Document 3.1 – ES Volume 2

Appendix 3.7: Response to S42 consultation 2019

Wheelabrator Kemsley (K3 Generating Station) and Wheelabrator Kemsley North
(WKN) Waste to Energy Facility DCO

Response to the S42 Consultation and S48 Publication 2019 Comments

**Figure 7.1: Construction HGV Route**

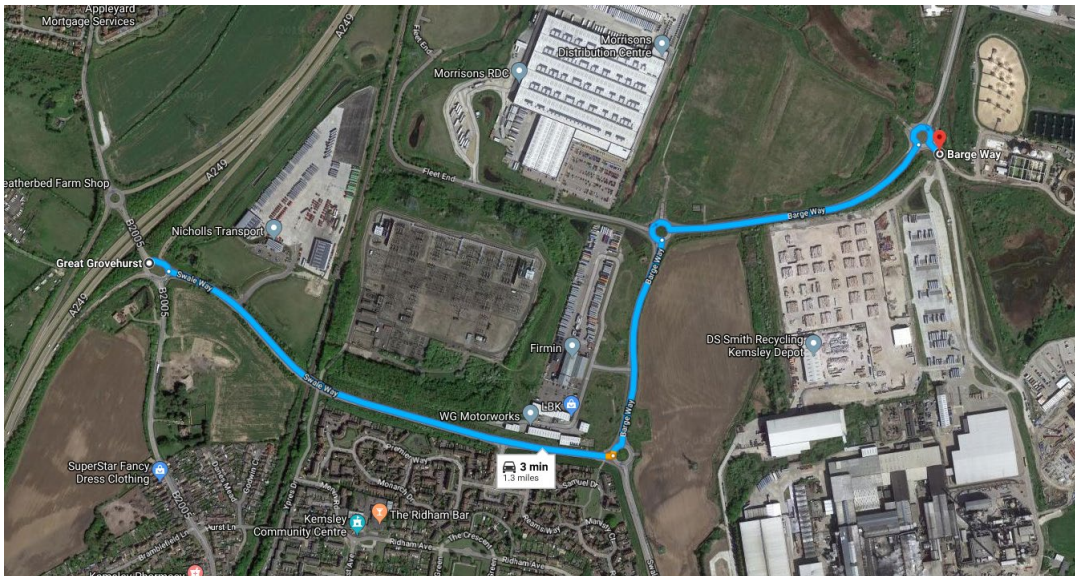
The consultation suggests that the volume of development generated traffic represents only a small proportion of the current traffic flows on the adjacent highway. This statement is disputed. Taking account of the currently submitted base movements of 2000, clearly the development generation of 666 represents a substantial impact on the volumes of HGVs. In addition, the completed counts as submitted would have included K3 construction HGVs, which would need be deducted and thus increase the overall development impact.

Updated 2019 junction assessments will need to be submitted.

The development will be expected to provide appropriate mitigation to any junction found to be operating above capacity as a result of cumulative development impact. This should be expected to be proportionate to the full amount of movements relating to the new application title.

An explanation will be provided for the numbers used and subject to discussion and agreement with KCC in the required Statement of Common Ground.

This will continue to be discussed with KCC and the subject of the required Statement of Common Ground.
